Appeal Decision

Appeal Ref: APP/R4408/W/18/3200763

Land off Milton Road, Hoyland, Barnsley S74 9BN

- The appeal is made under section 78 of the Town and Country Planning Act 1990 against a failure to give notice within the prescribed period of a decision on an application for planning permission.
 - The appeal is made by Mr Doug Shelley against Barnsley Metropolitan Borough Council.
 - The application Ref 2017/1285 is dated 21 September 2017.
 - The development proposed is described as proposed mixed Use development. Erection of 3 commercial units for uses A1 retail & A2 office.
-

LP-01 Proposed Site Block Plan 1:500

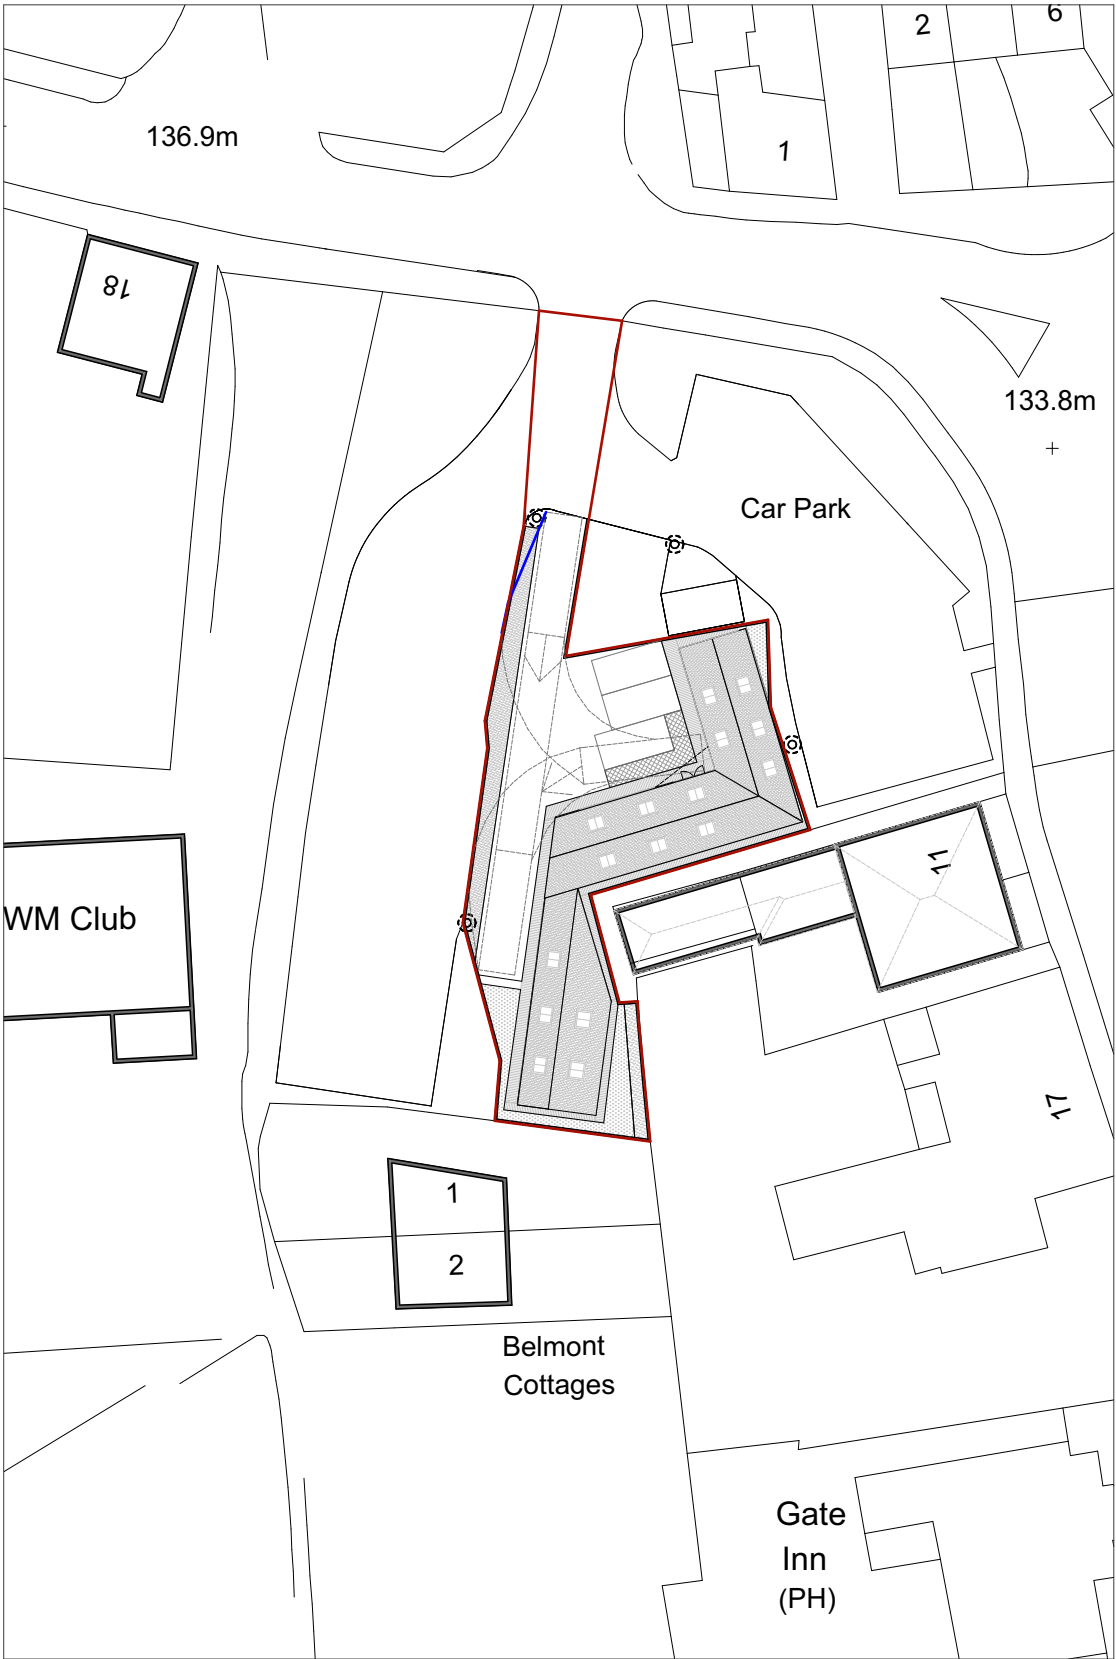
3. The appeal site is within a car park on the southern side of Milton Road. At the time of my site visit the car park was full, with vehicles parked very close to the appeal sites boundaries. In order to avoid conflict with parked vehicles and those entering and leaving the car park I consider it would be necessary for vehicles to enter and leave the appeal site in a forward gear. As the appeal proposal relates to A1 and A2 uses it appears likely that both larger delivery and refuse collection vehicles would need to access the appeal site.

4. A number of the plans submitted with the planning application show the tracking of a vehicle turning within the appeal site. Although the appellant's written evidence refers to the scheme being designed around an 11.85m refuse collection vehicle, I have very limited detailed information to explain how this tracking has been plotted or assessed. There are no dimensions or radii shown on the plans. The method by which the tracking has been plotted is not shown either. In the absence of this information I am unable to assess the ability of a larger vehicle to turn within the site and the consequent effect on highway safety.
